# Submissions Report

EQUIS ENERGY (AUSTRALIA) PROJECTS (NGUMI 4) PTY LTD AS TRUSTEE FOR EQUIS ENERGY (AUSTRALIA) NGUMI 4 HOLDING TRUST PTY LTD

MAY 2024

This Submissions Report relates to the proposed standalone battery energy storage system (BESS) with a storage capacity up to 300MW and 600MWh discharge capacity, and connection to the existing Tamworth substation via underground transmission cable, and ancillary works at 474 Calala Lane, Calala (the site) and has been prepared on behalf of Equis Energy (Australia) Projects (Ngumi 4) Pty Ltd as trustee for the Equis Energy (Australia) Ngumi 4 Holding Trust (Equis) (the Applicant). The project has been amended to address the concerns raised in submissions, and a description of the amendments proposed are outlined in the Amendment Report submitted in conjunction with this Submissions Report. This Submissions Report has been prepared to address the matters raised by the Department of Planning, Housing and Infrastructure (DPHI), public agencies, Council, and objectors. The State Significant Development Application (SSDA) was lodged with the DPHI (formerly the DPE) in November 2023 (SSD-52786213).

Project No.	Drawing No.	Issue
SY22-086	-C-0 700	A

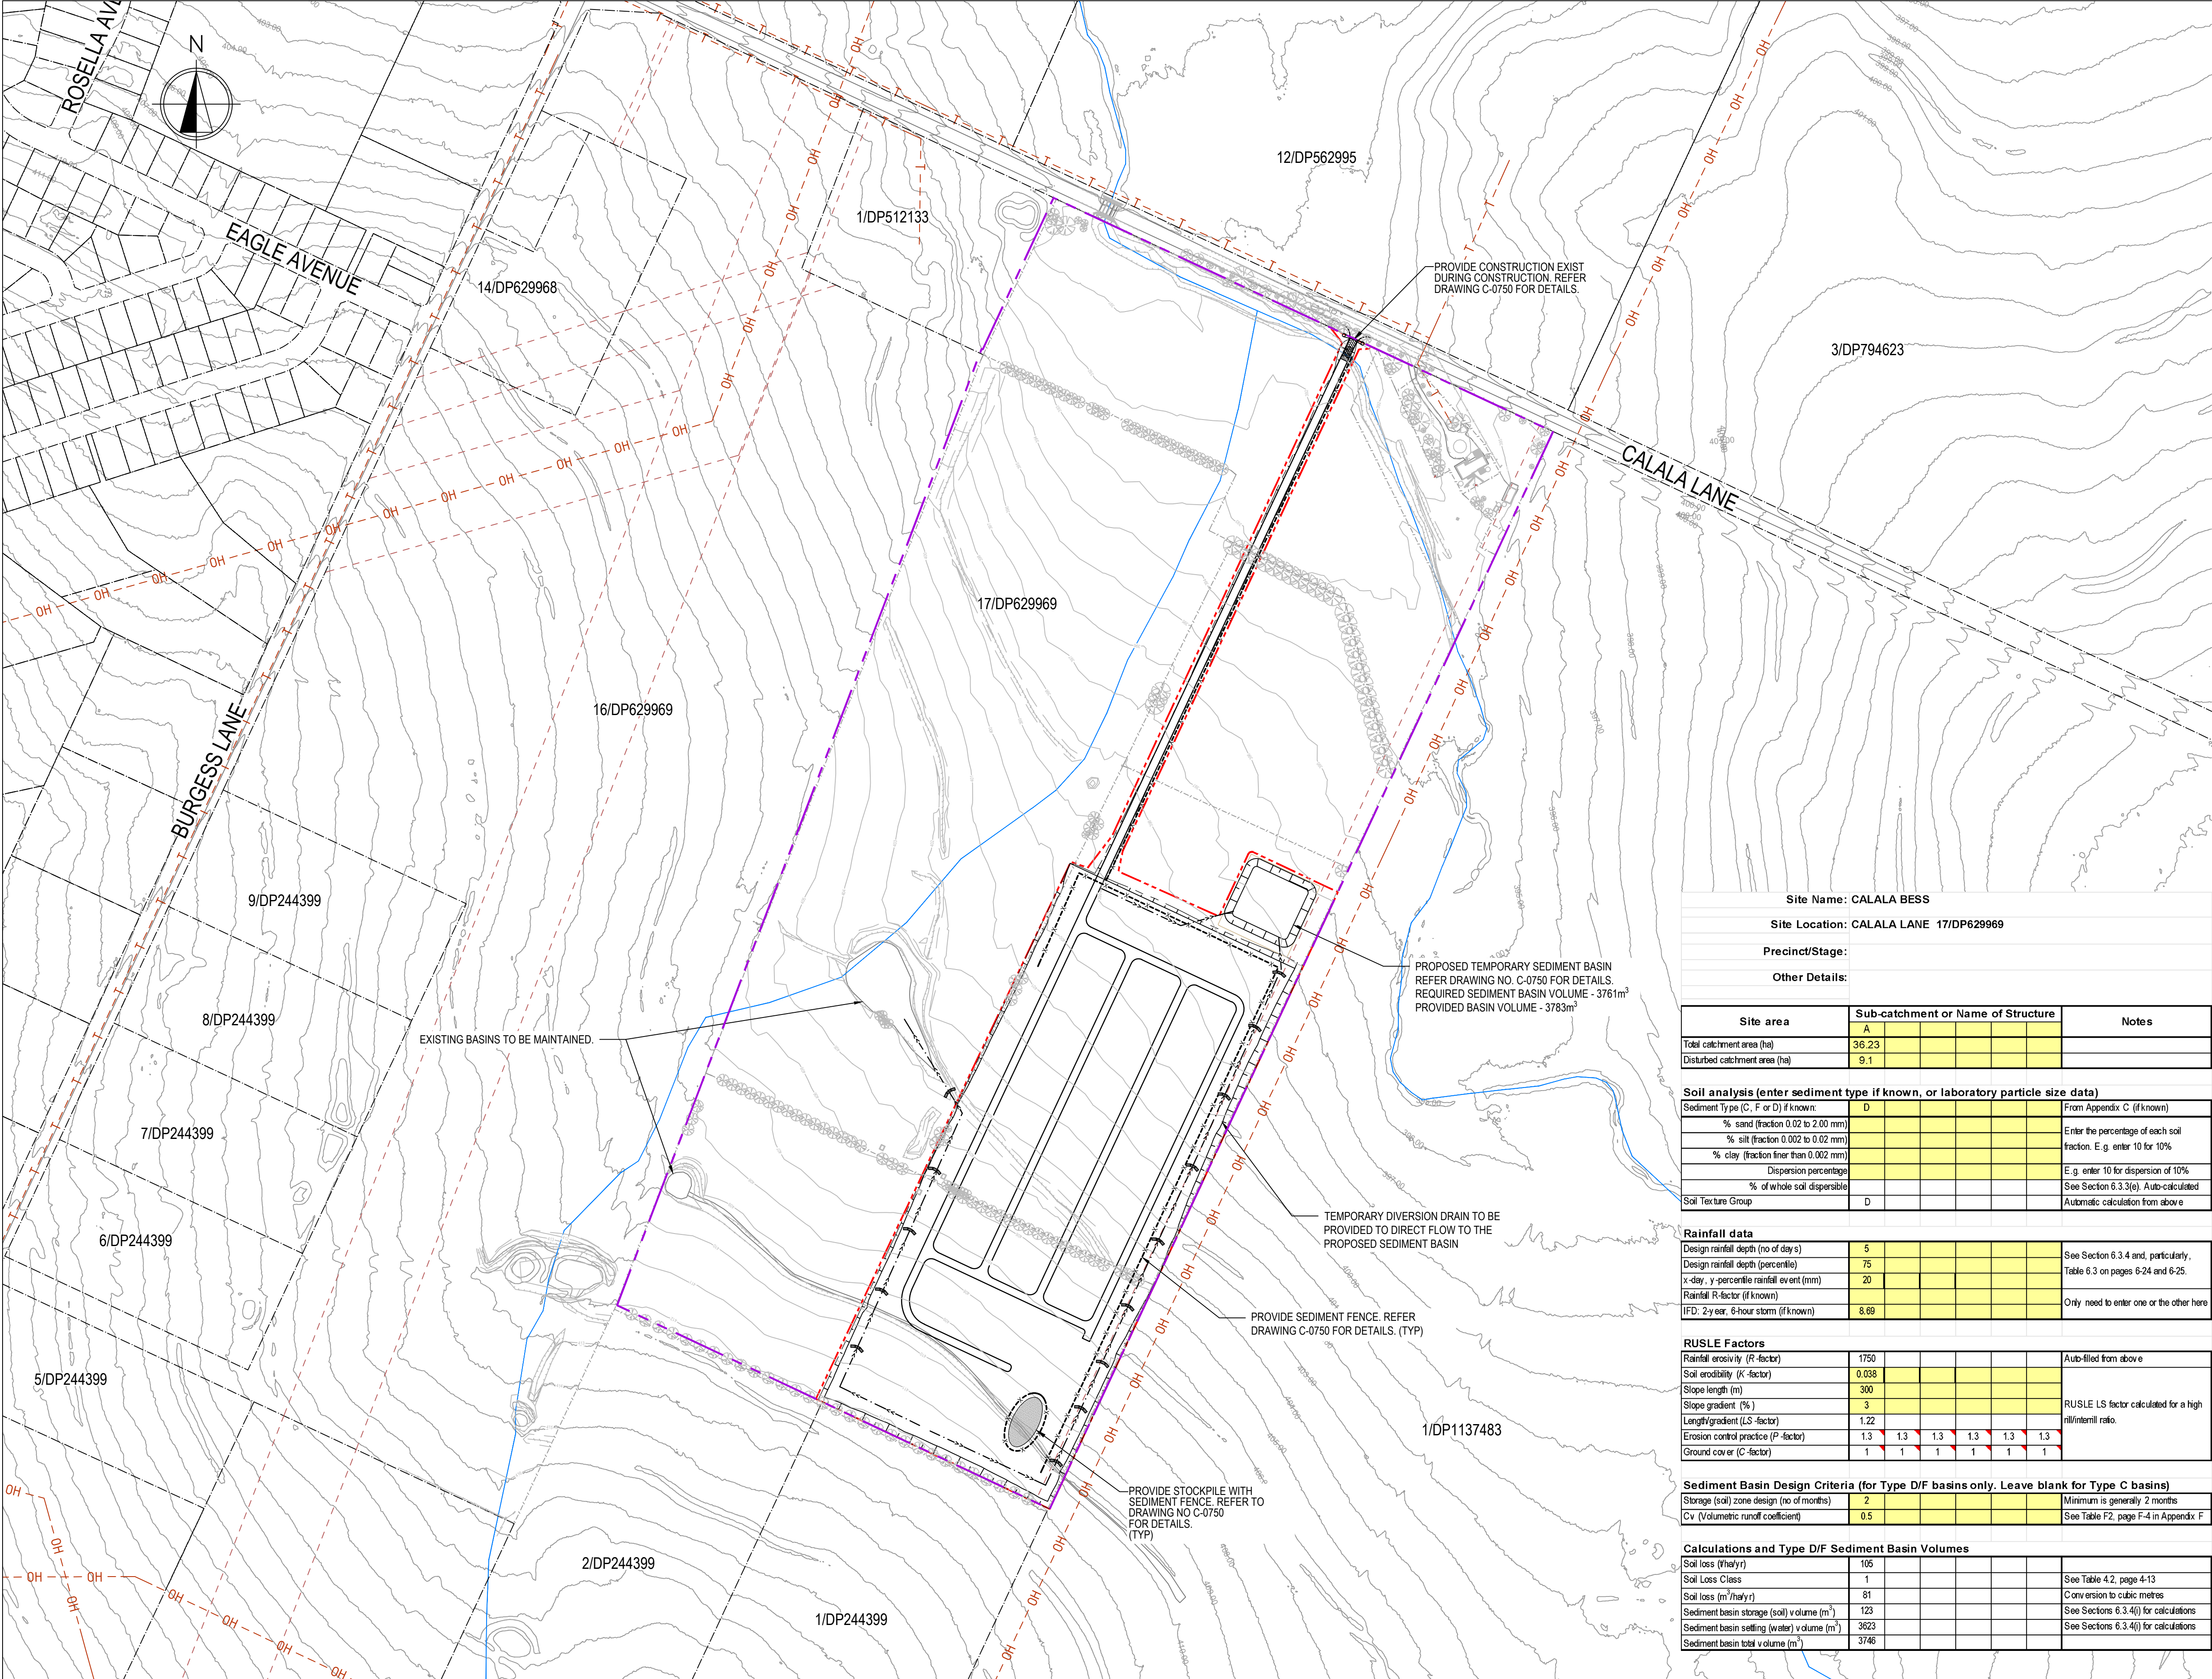
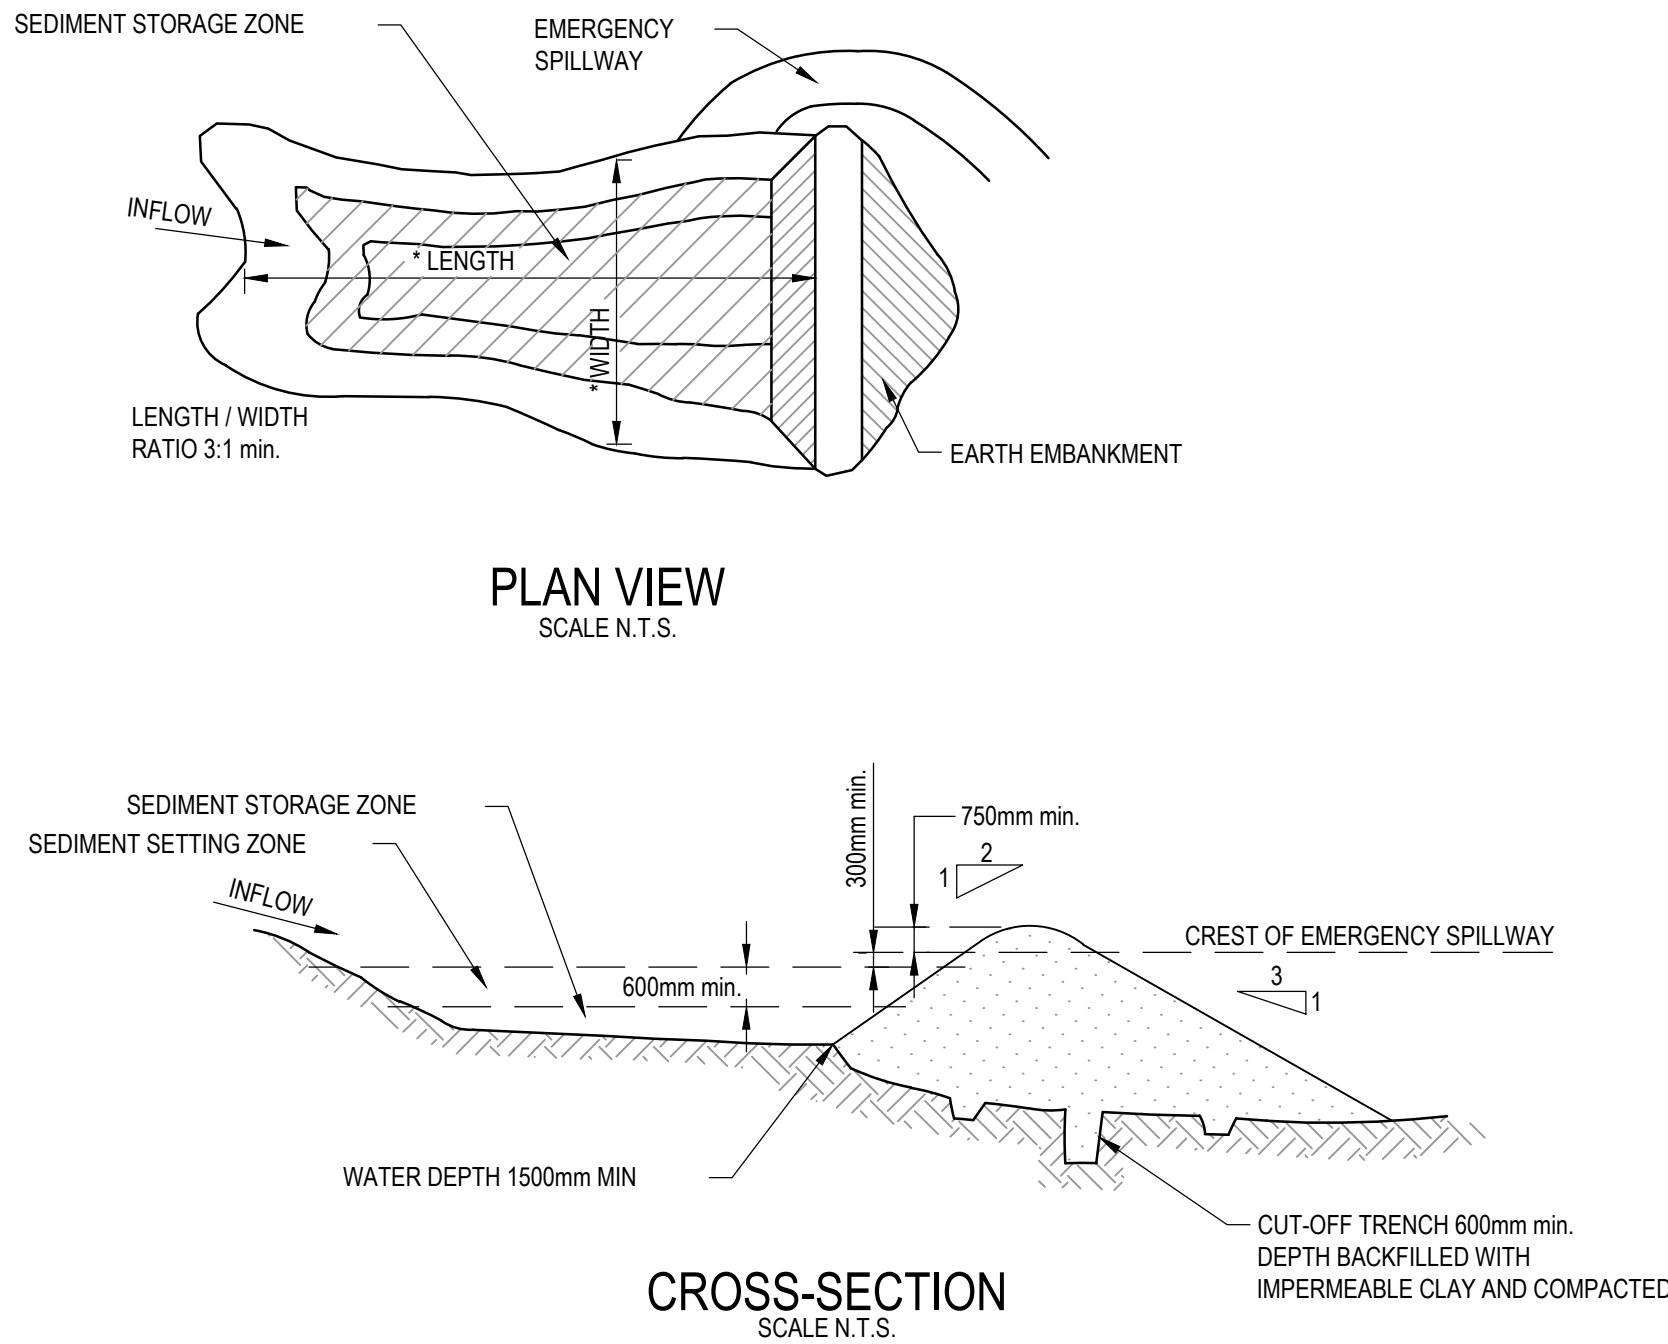
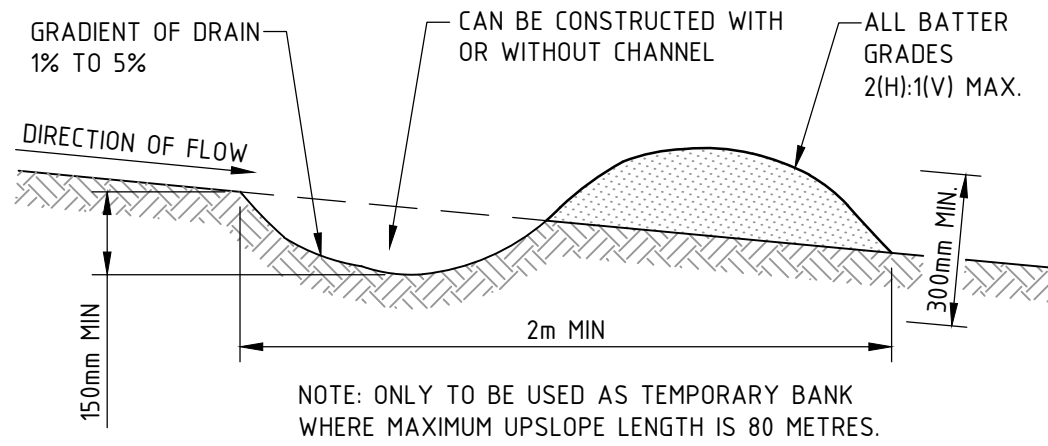
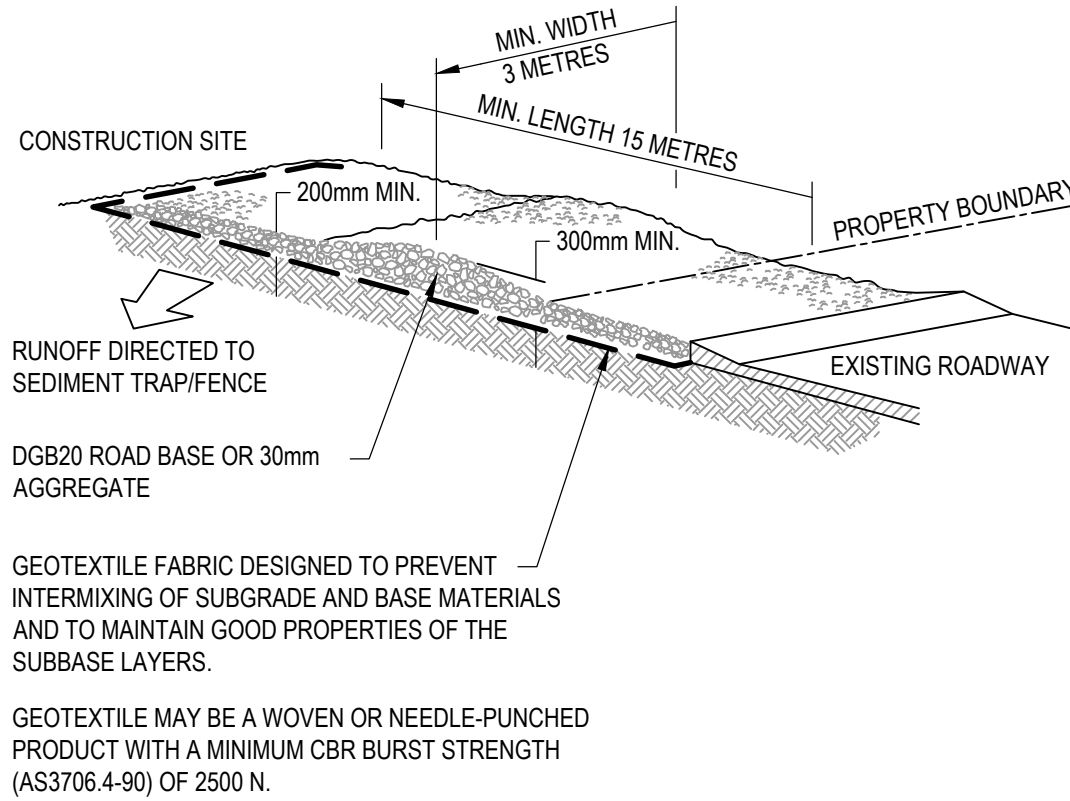
<p><b>4. <u>Erosion and Sediment Controls</u></b></p>	<p>The Erosion and Sediment Control Plans provided in the Civil Engineering drawings by Sky Engineering,</p>

<p>The Applicant has indicated a commitment to prepare a Soil and Water Management Plan (SWMP) in accordance with the 'Blue Book' Volume 1 Managing Urban Stormwater: Soils and Construction (Landcom 2004). TRC stresses the importance of managing stormwater and soils to prevent offsite impacts and recommends the Applicant to look at synergies between managing the groundcover and stormwater runoff.</p>	<p>submitted with the Environmental Impact Statement (EIS), comply with the Blue Book, including a sediment basin, sediment fencing, and diversion drains with straw bale filters, alongside measures to divert run-on flows from upslope away from the construction area. Further discussion on erosion and sediment controls is found in the Water Management Report. Refer to Northrop's letter dated 7 February 2024 in Appendix E for further details.</p>
	<p><b>5. <u>Resource Use and Waste Generation</u></b></p> <p>The EIS commits to a detailed Waste Management Plan. TRC agrees this is necessary but wishes to comment on the timing. A detailed plan for managing the waste material during the construction phase needs to be developed in consultation with TRC prior to construction. The Waste Management Plan must include options for diverting recoverable or recyclable waste streams from landfill, including recoverable or recyclable options that are outside of the Tamworth Local Government Area. It also needs to detail all types of packaging and material from the construction phase. A condition requiring that the construction phase of the Waste Management Plan be approved prior to construction commencing is recommended.</p> <p>Further details of decommissioning must be provided and a requirement that information regarding decommissioning be updated during the life of the project be included in the conditions of any consent.</p>	<p>Council's comments are noted. A Waste Management Plan will be developed following consent being granted for the development. The WMP will incorporate any demolition, construction, ongoing and decommissioning phases of the development.</p>
